# CITY OF ALBUQUERQUE

**Re: First Nations Community Healthsource, Building C, BP-2019-31804**  
**5608 Zuni Road SE, 87108**  
**30-Day Temporary Certificate of Occupancy**  
**Transportation Development Final Inspection**  
Engineer's/Architect's Stamp dated 7-28-17 (L18D047)  
Certification dated 04-25-19

AS-TCL

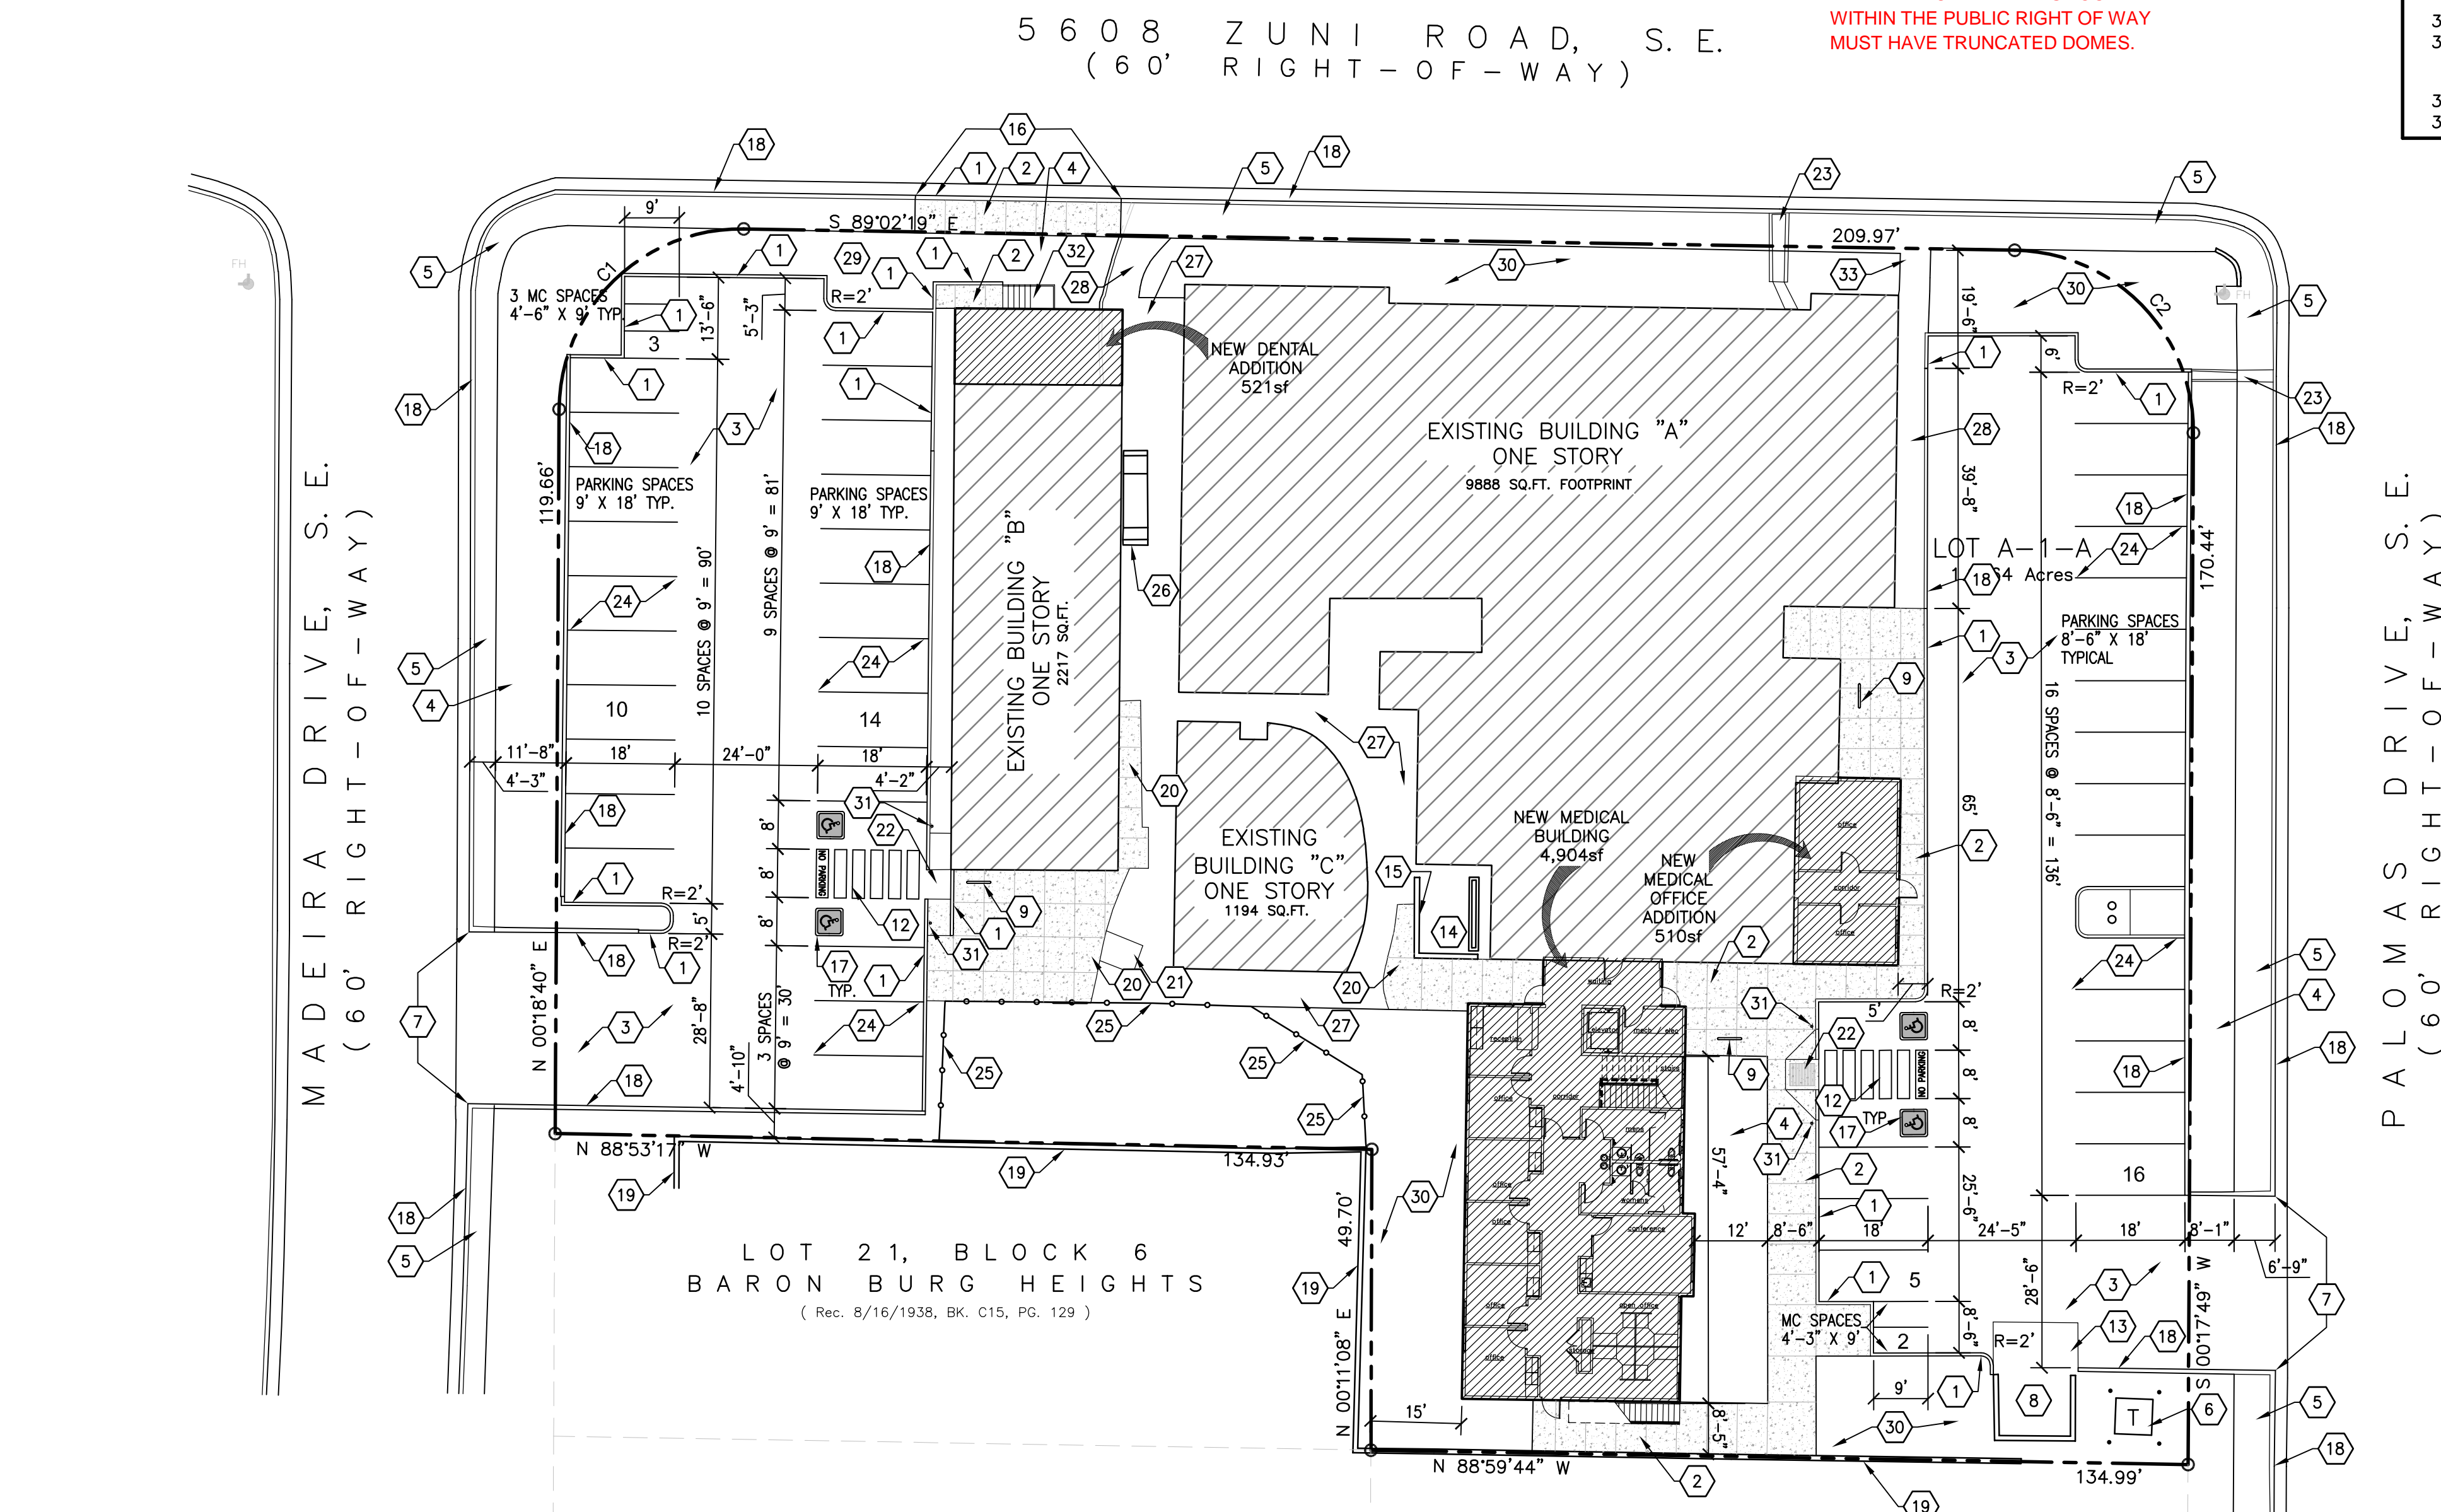
1. Please widen ADA walk path even with wheel stop.  
(See attached photo)  
Measurement taken at site measured @ 3 foot 6 inches.
